Consultee Comment for planning application 22/01340/OUT

Application Number	<input type="text" value="22/01340/OUT"/>
Location	<input type="text" value="Os Parcel 6124 East Of Baynards Green Farm Street To Horwell Farm Baynards Green"/>
Proposal	<input type="text" value="Application for outline planning permission (all matters reserved except means of access (not internal roads) from B4100) for the erection of buildings comprising logistics (use class B8) and ancillary offices (use class e(g)(i)) floorspace; energy centre, hgv parking, construction of new site access from the B4100; creation of internal roads and access routes; hard and soft landscaping; the construction of parking and servicing areas; substations and other associated infrastructure."/>
Case Officer	<input type="text" value="Tom Webster"/>
Organisation	<input type="text" value="Drainage (CDC)"/>
Name	<input type="text" value="Tony Brummell"/>
Address	<input type="text" value="Cherwell District Council Bodicote House White Post Road Bodicote Banbury OX15 4AA"/>

Drawing Number: **10387340-HDR-XX-XXX-DR-C-303**

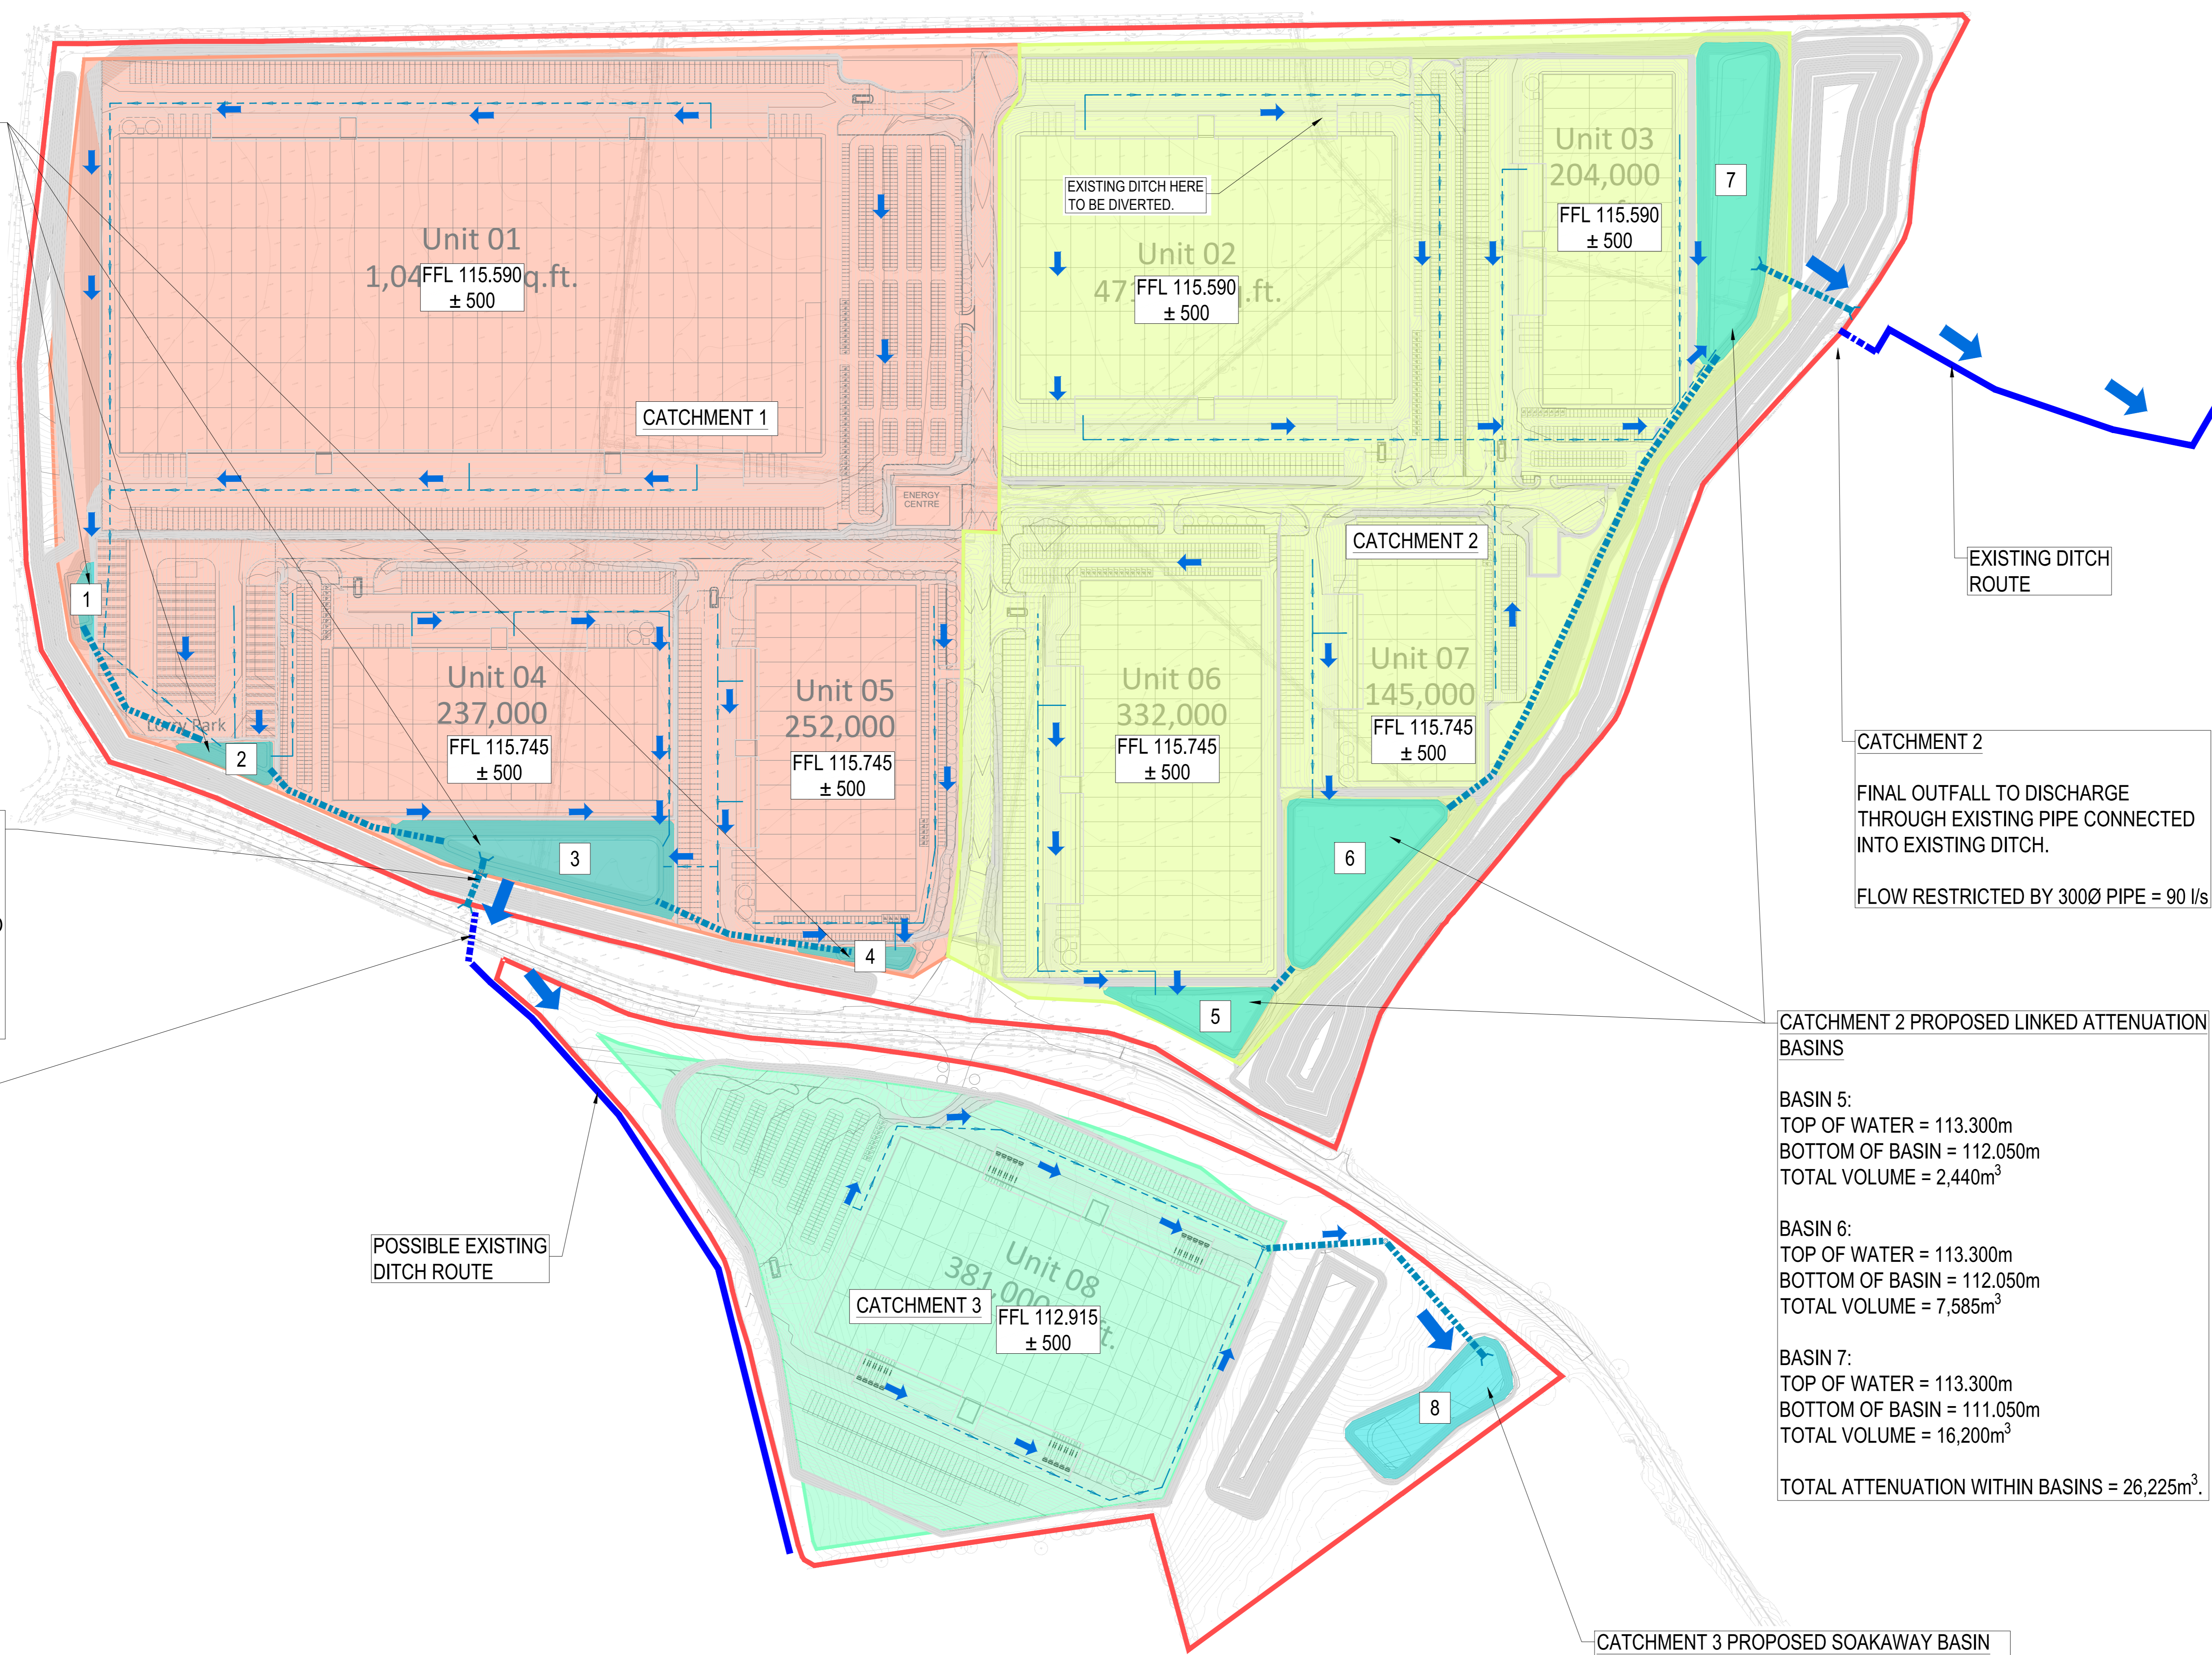
Chapter 11 of the Environmental Statement May 2024 (particularly paragraph 11.9.7 on p 247/330) refers. The surface water drainage strategy is in principle satisfactory but must be the subject of further comments by Oxfordshire County Council as LLFA and the Buckingham and River Ouzel Internal Drainage Board. The site discharge will enter a tributary of the Padbury Brook a little upstream of the IDB area.

In summary, the strategy is to provide on-site green attenuation basins to limit the discharge from the site to the greenfield rate for all events up to the 1% AEP + 40% CC event. The attenuation basins will provide as much opportunity as is feasible for infiltration. The porosity of the subsoil and thus the potential for infiltration has not yet been fully investigated."/>
Received Date	<input type="text" value="13/06/2024 10:02:48"/>
Attachments
